**WEST SUSSEX COUNTY COUNCIL
PLANNING SERVICES CONSULTATION**

SUBJECT: M/86/17/PL - Retention of salon, erection of first floor extension & two storey rear extension to create 1 No. dwelling.

74, Elmer Road, Middleton on Sea, West Sussex, PO22 6EX

Client	Ms K. Jane		
Job	Sarahs' Hair Salon 74 Elmer Road, Bognor Regis, West Sussex. PO22 6 EX		
Drawing	Proposed Extension and Alterations Existing and Proposed Plans		
Date	August 2017	Scale	1:100 at A3
Drawn By	L.O.	Dwg. No.	010817 / SL-30 A

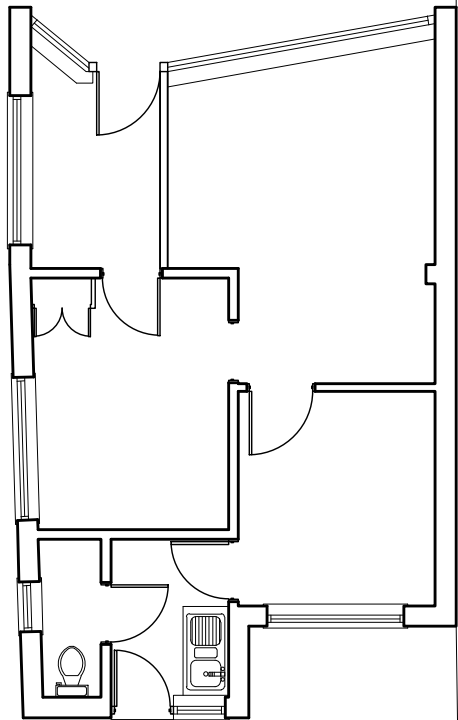
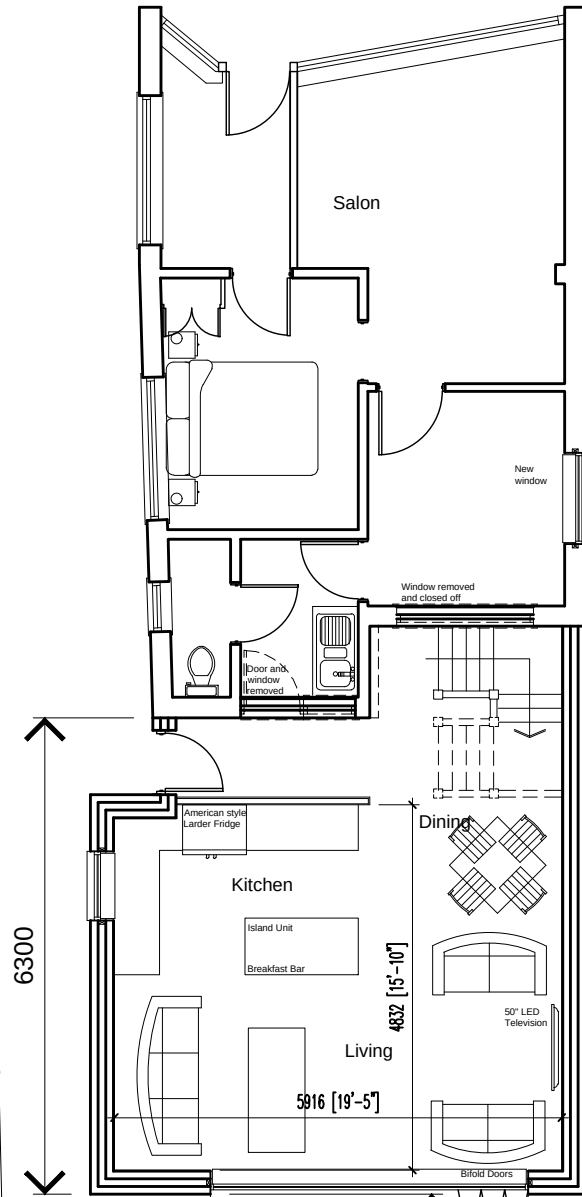
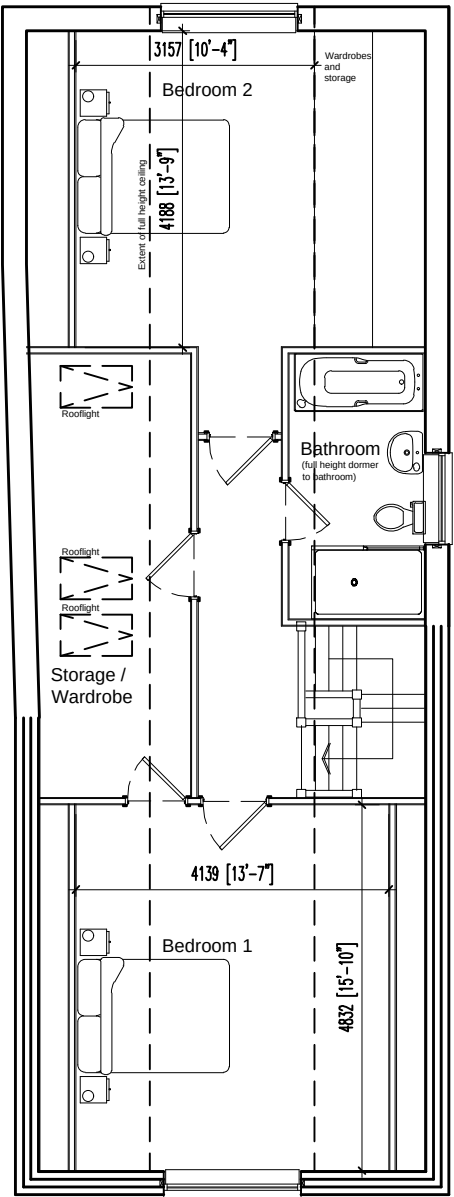
The application form states that two spaces exist at present and three will be provided. Based upon the floor plan provided (010817 / SL-30 A) it would appear that the rear garage will no longer be accessible due to the extension works and will be removed and replaced with a garden/yard area. Only one car parking space, allocated to the residential unit, has been annotated on the plans provided which will be accessed via an existing point of access onto Elmer Road.

While the Local Highway Authority (LHA) would have no concerns with the continued use of this access point to serve a parking space for the residential unit I would be concerned that the location of this space obstructs the extent of publically maintained highway in this location, to assist I include a 1:500 scale highway boundary plan.

I would however accept that the parking space as annotated can be pushed back into the site and would therefore advise that the precise location of the parking space is secured via planning condition, with plans and details to be submitted to and approved by the local planning authority. The applicant is advised that the space should measure 2.4 x 4.8 metres and not intersect with the areas indicated as public highway on the attached plan.

An appropriate cycle storage provision have been indicated on the proposed plans, this provision should be secured via planning condition in the interests of sustainable transport policies.
